Subject:       Munjoy Heights  
                  Final Level III Site Plan Application  
                  Comment Response Letter

On behalf of Redfern Properties, LLC we are pleased to respond to Woodard & Curran's November 20<sup>th</sup>, 2013 Memorandum.

**Woodard & Curran – Peer Review Memo**

DRAWING NO.  
**C-20**

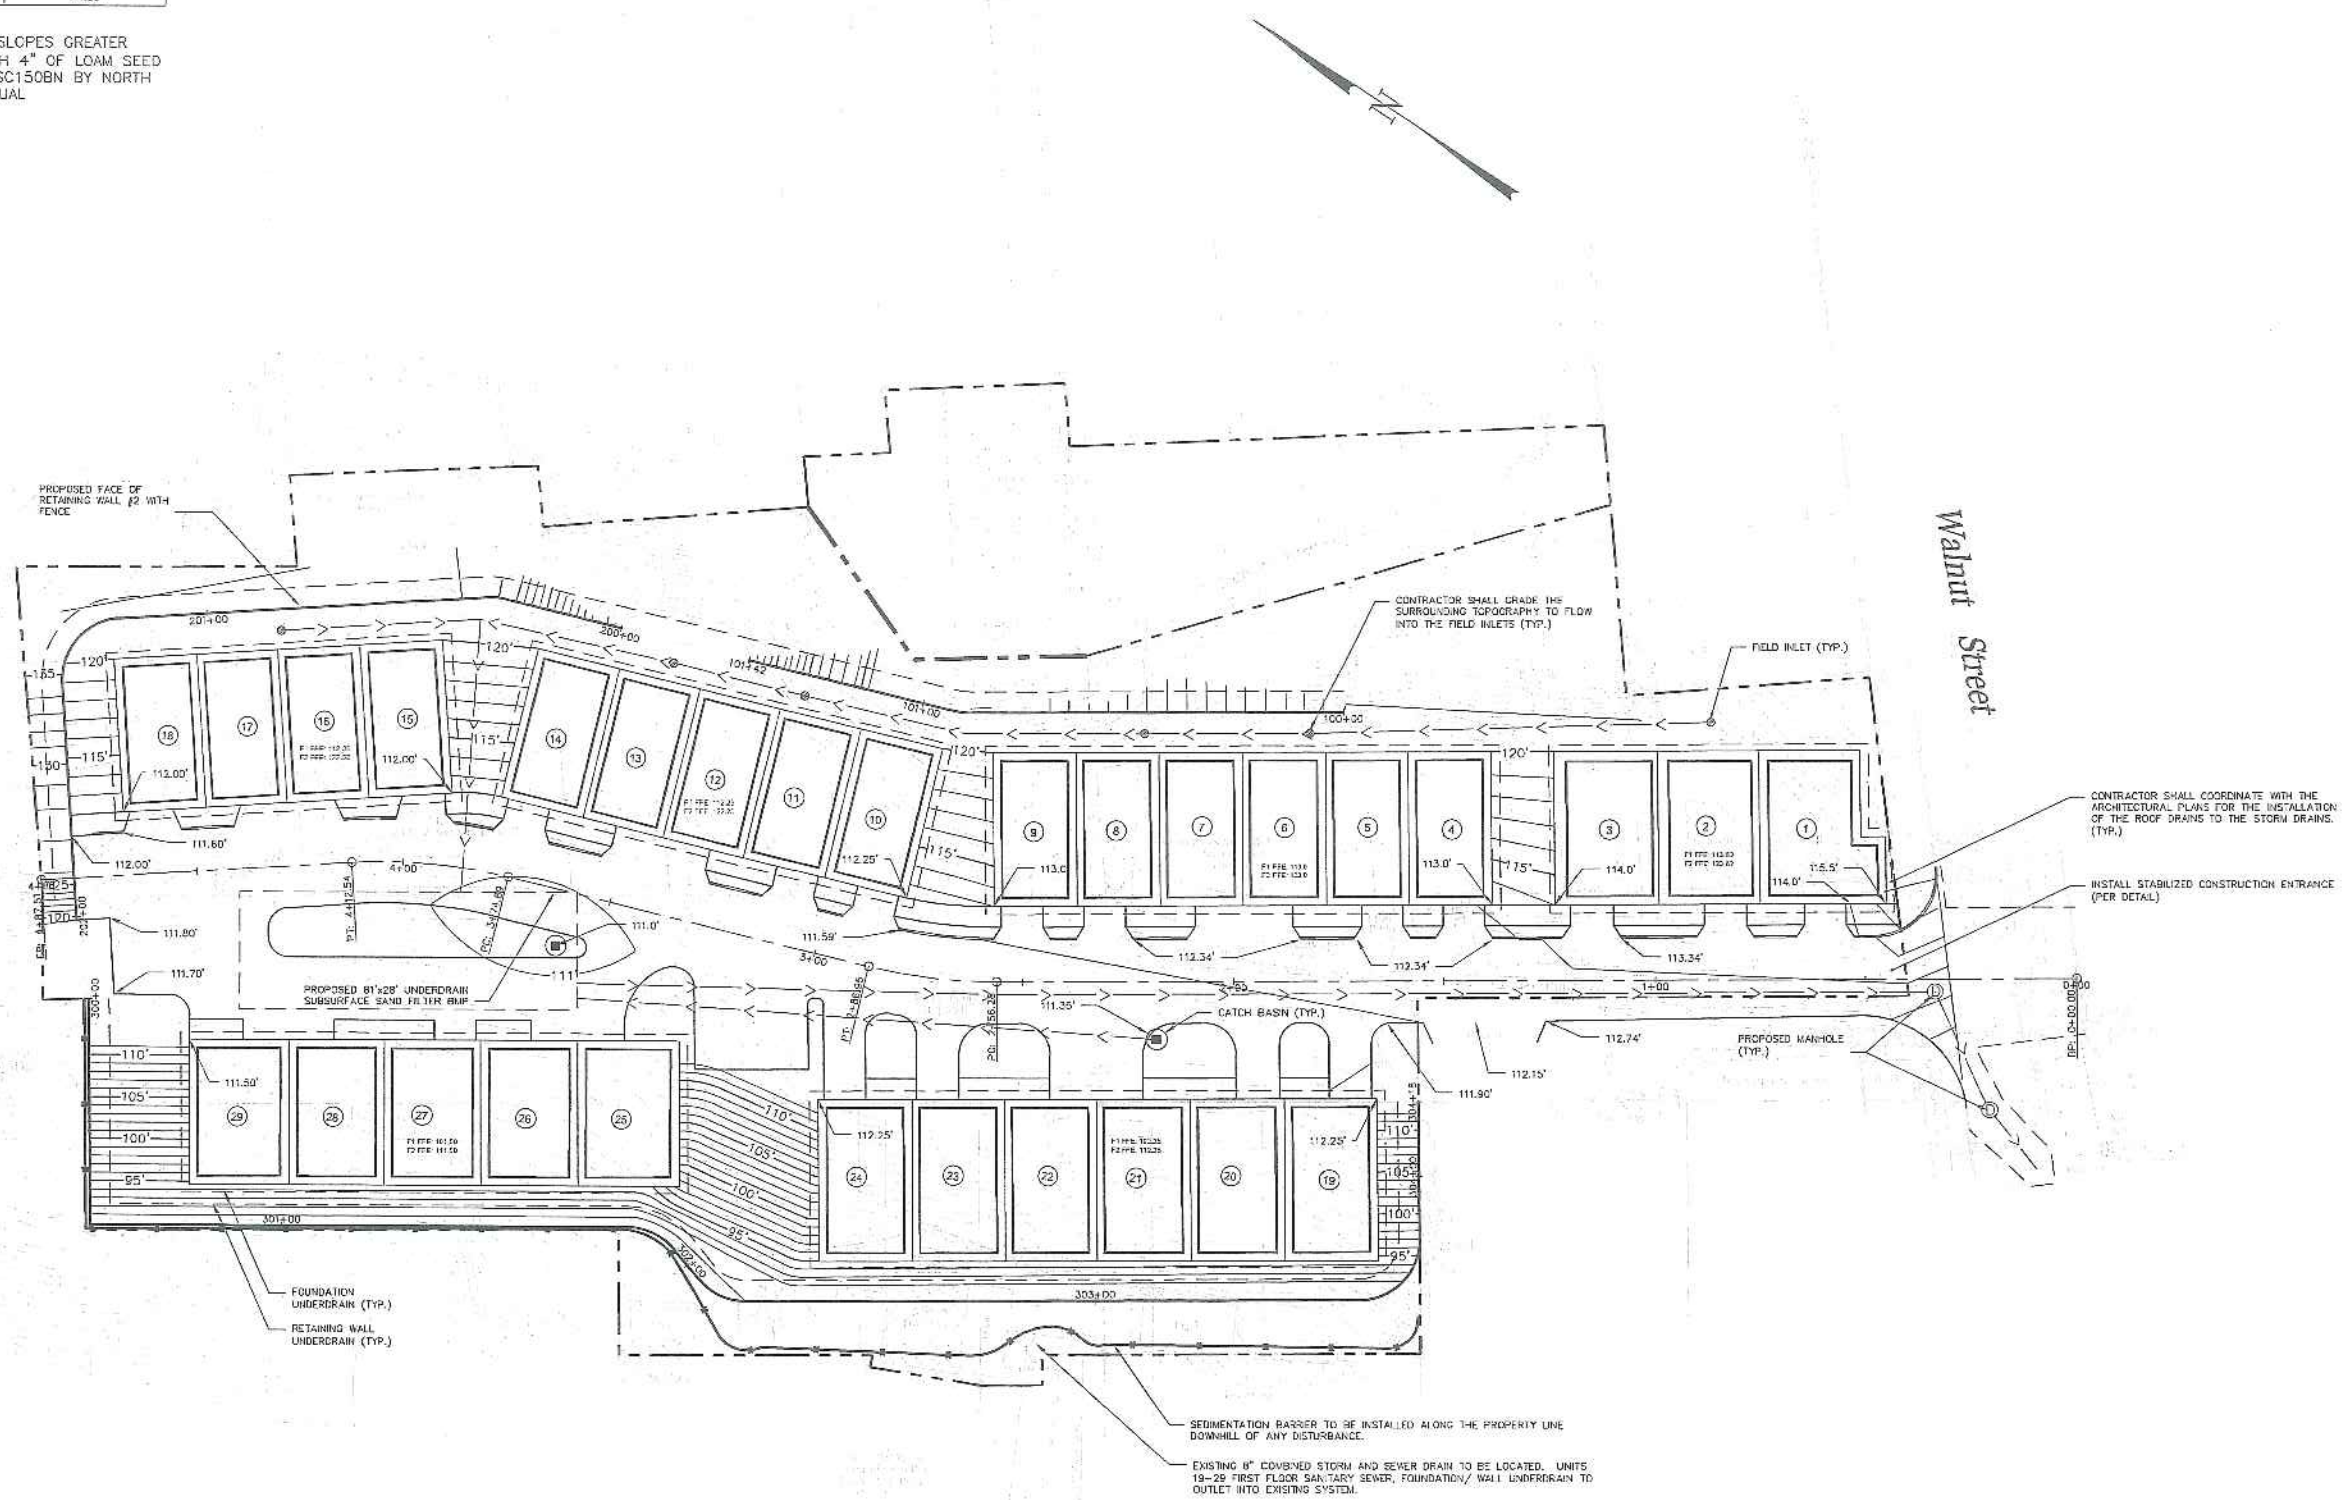
12) *Sheet C-20 depicts a site sewer pipe below the trees located along the north edge of the woonerf. We recommend shifting the utilities south to avoid root penetration and potential conflicts with the trees and the sewer system.*

13) *Sheet C-20, Note 5 states that the units have individual service connections to the utilities, but that these service connections are not shown for clarity. Utility connections to all buildings should be included on the plans.*

14) *Sheet C-20, Note 6 states that transformer pad locations will be determined by CMP prior to construction. The plan should indicate potential transformer pad locations (based on unit needs and setbacks); these can be labeled as approximate pending confirmation by CMP and future review /approval of the City.*

15) *Sheet C-20, the pavement sawcut proposed across Walnut Street should be squared off on the north and south side of the work, with a straight line across the road running curb to curb.*

16) *Sheet C-20, it is unclear how fire and domestic water services can be provided to Units 1,2 & 3 given the location of the fire meter pit relative to the building.*

**Response** – The following response is from Soren Deniord, “All proposed trees within a 5' proximity of the sewer pipe will be planted at a depth no greater than 3' deep. Permeable landscape fabric will be used to create a root barrier around sewer pipes.”

Acorn Engineering also added a note to Drawing C-20 allowing the Contractor to obtain approval from the PWD to reduce the horizontal separation from 10 ft. to 5 ft. thereby shifting the sewer pipe away from the proposed trees.

**Response** – Drawing C-20 now includes the approximate location for individual water and sewer service connections.

**Response** – Drawing C-20 now includes potential transformer pad locations.

**Response** – Drawing C-20 the proposed sawcut line is now perpendicular to the existing curb.

**Response** – This should be clarified with the addition of the proposed individual service connections.

UNDERDRAINED SUB-SURFACE SAND FILTER
TYPICAL CROSS SECTION
NOT TO SCALE

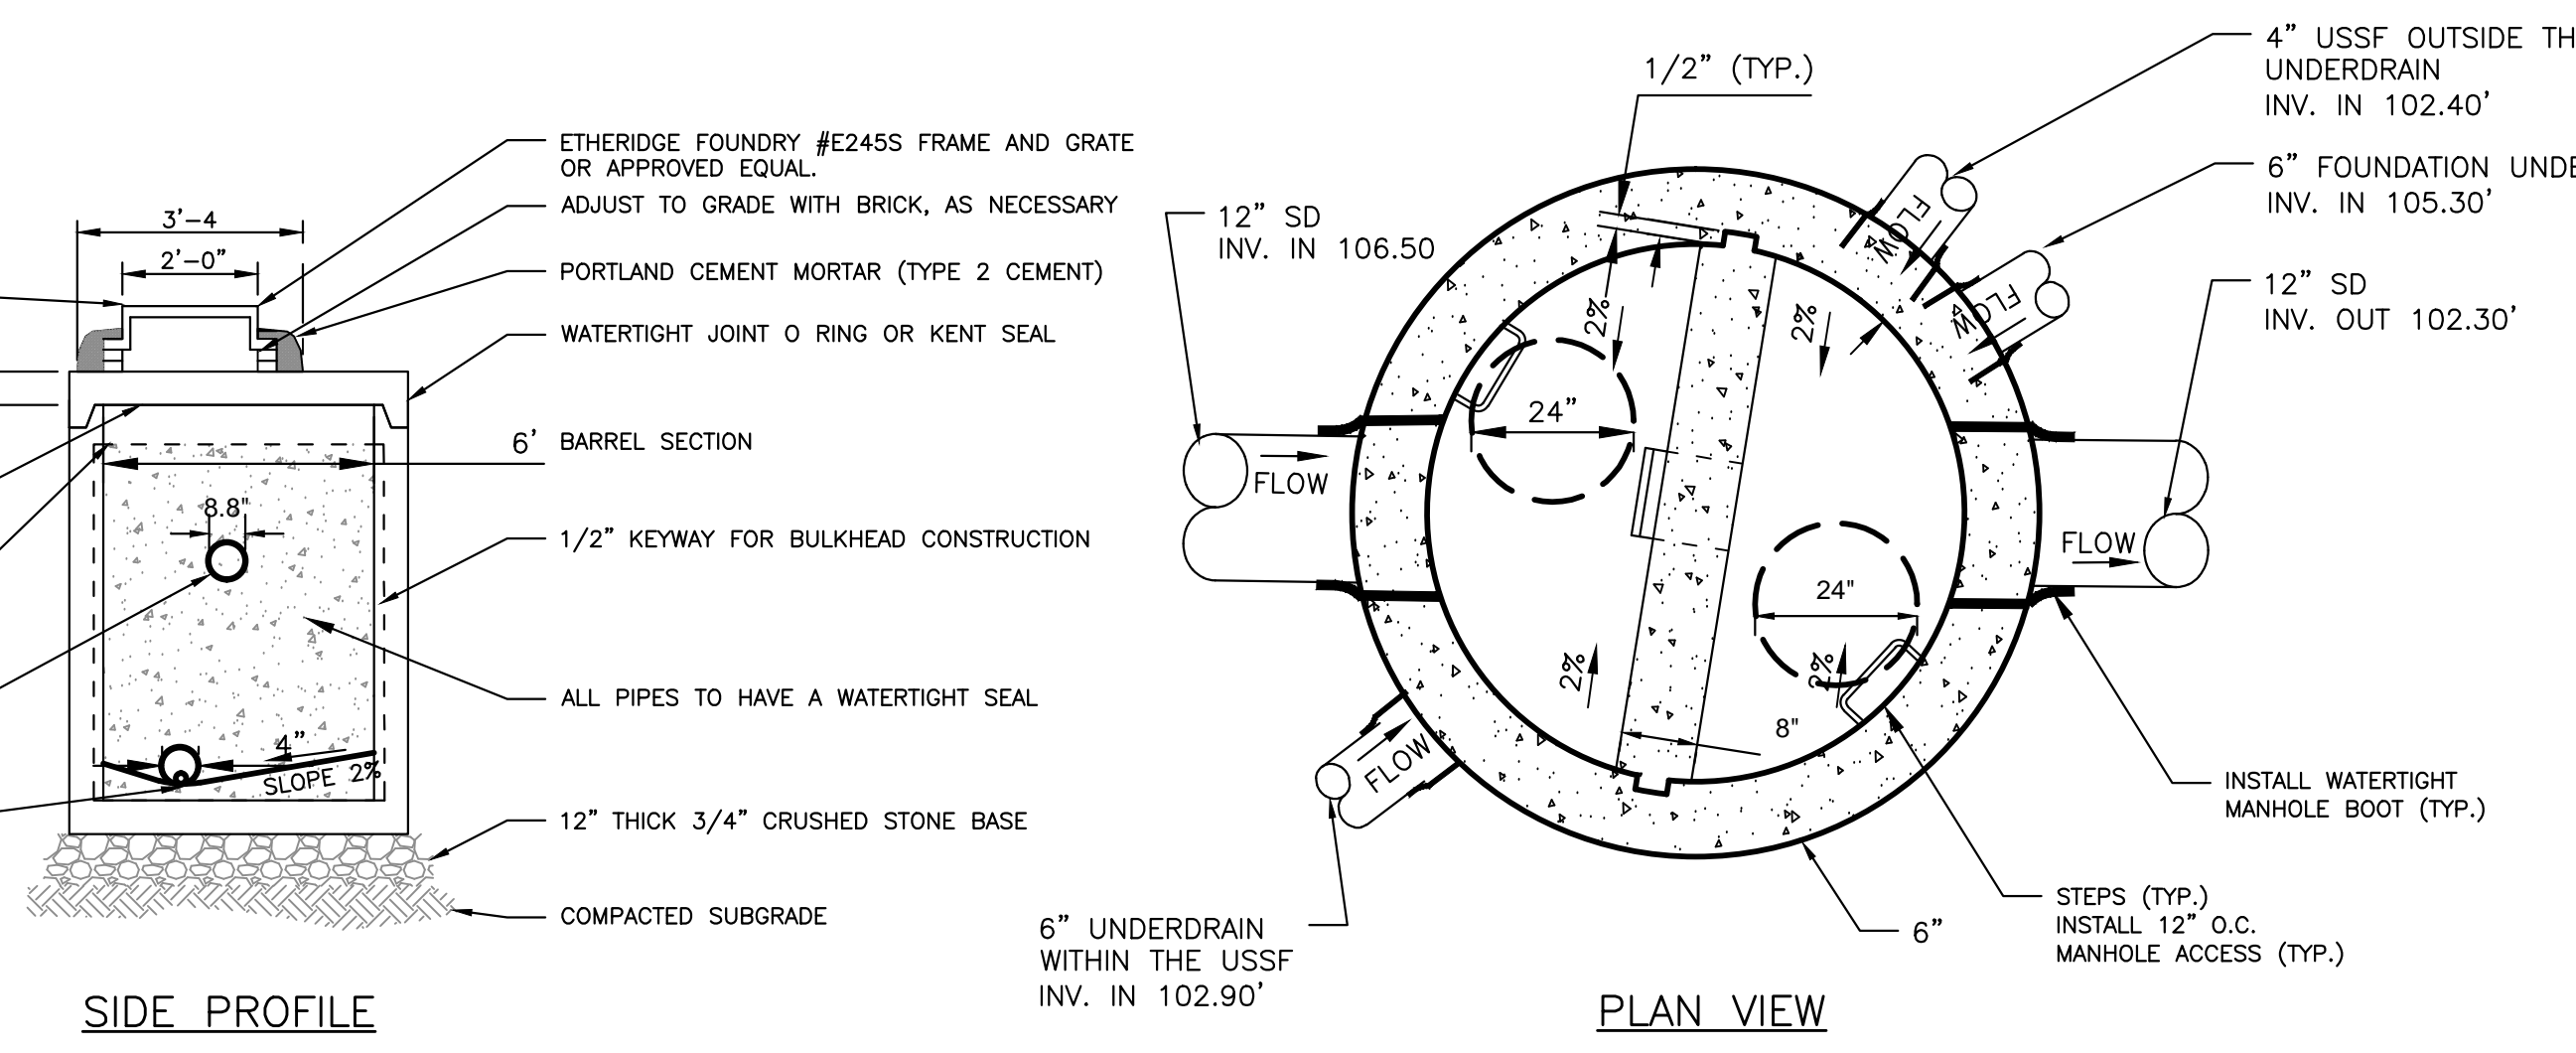
- ii) Pond 1P within the HydroCAD report - the depth of crushed stone in “Volume #2” has been modeled as 3.5-feet; however, it is detailed on the plans as 3.25-feet. The Applicant should clarify and revise as necessary.*

**Response** – The detail was revised match the HydroCAD Report.

STANDARD PRECAST SEWER MANHOLE
NOT TO SCALE

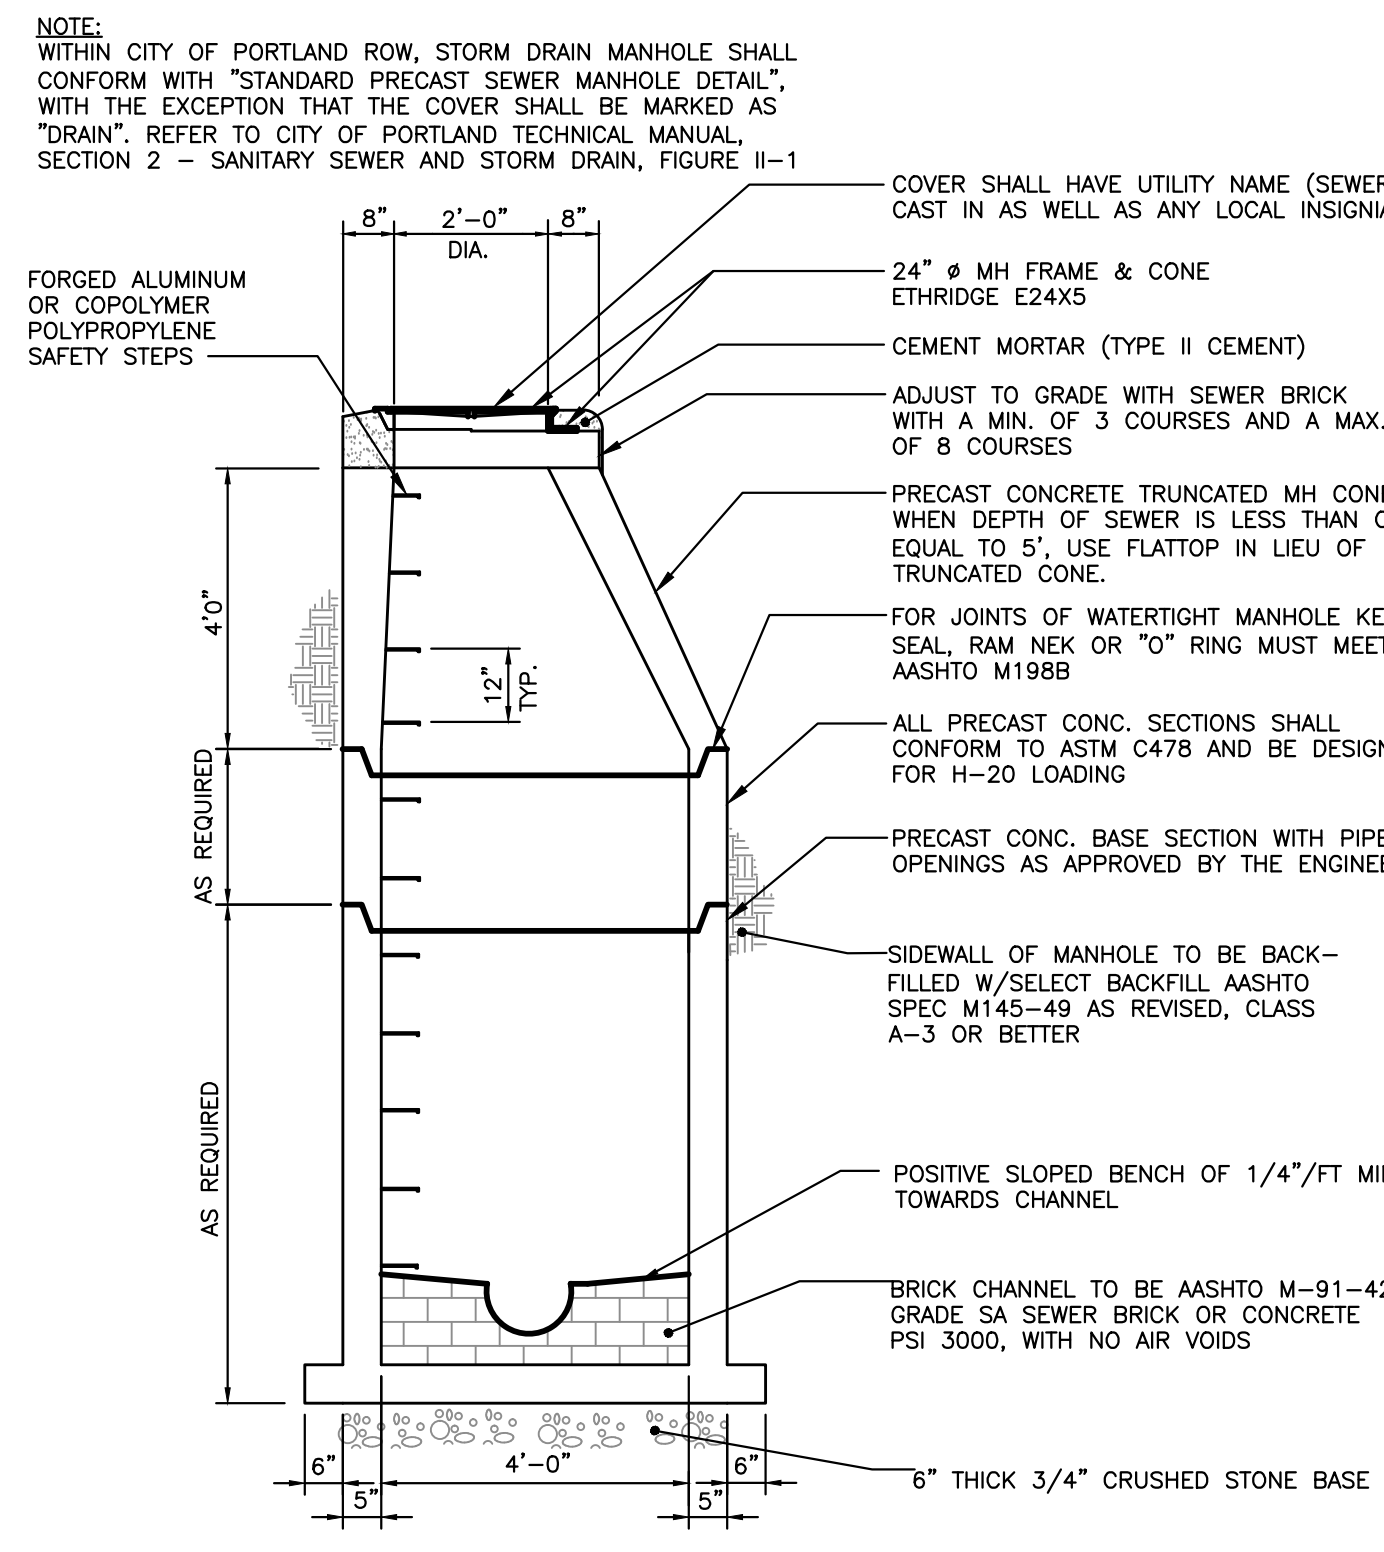
24) *Sheet C-41, the proposed Drain Manholes within the City Right-of-Way should match the Standard Precast Sewer Manholes, with the cover marked as “Drain”.*

**Response** – On Drawing C-41 a note was added to the Standard Precast Sewer Manhole to address the comment above.

RAIN GARDEN OR BIORETENTION CELL DETAIL

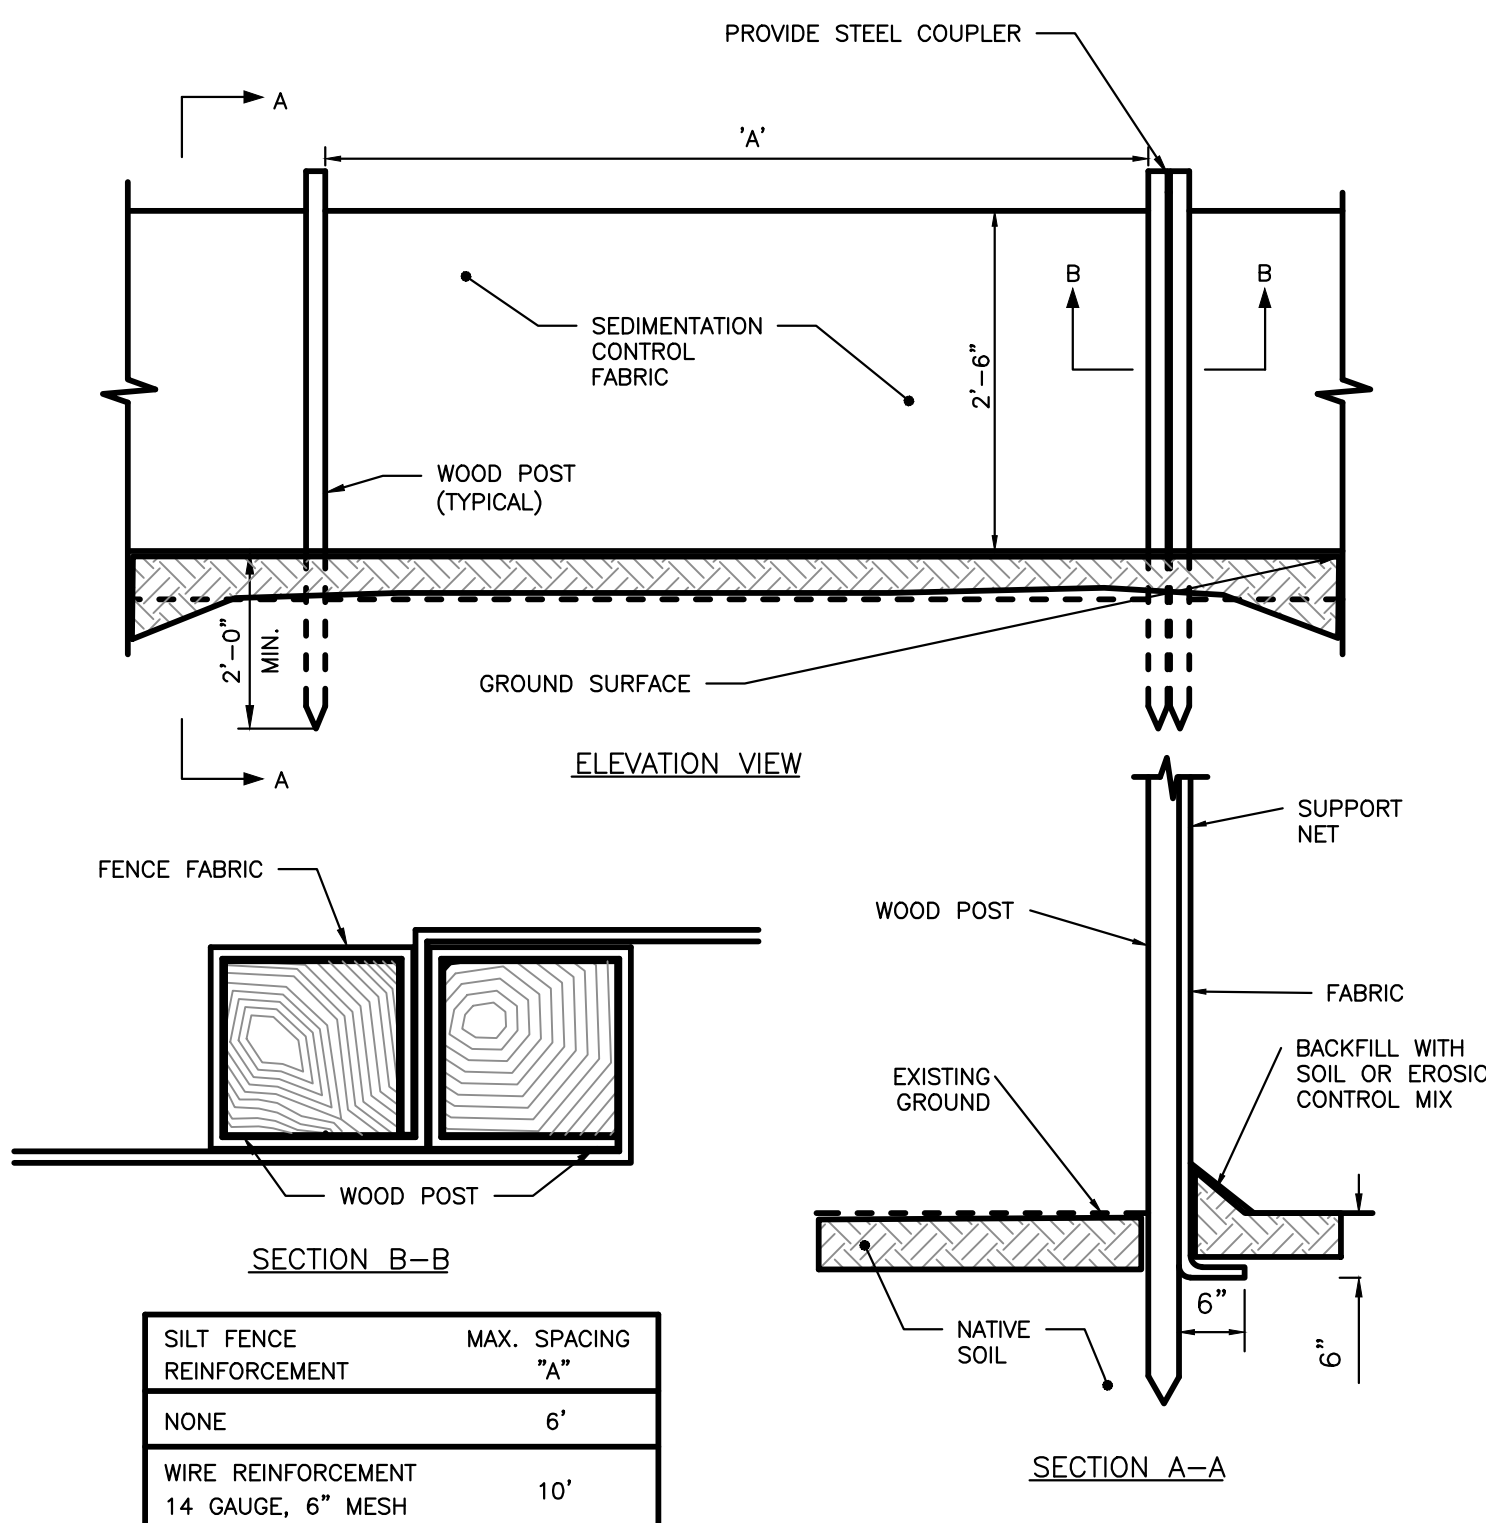
17) *Sheet C-30 indicates a proposed location for potential rain gardens. Future submissions should clarify the design of these rain gardens.*

**Response** – *Drawing C-30 and C-42 clarify the design of the rain gardens.*
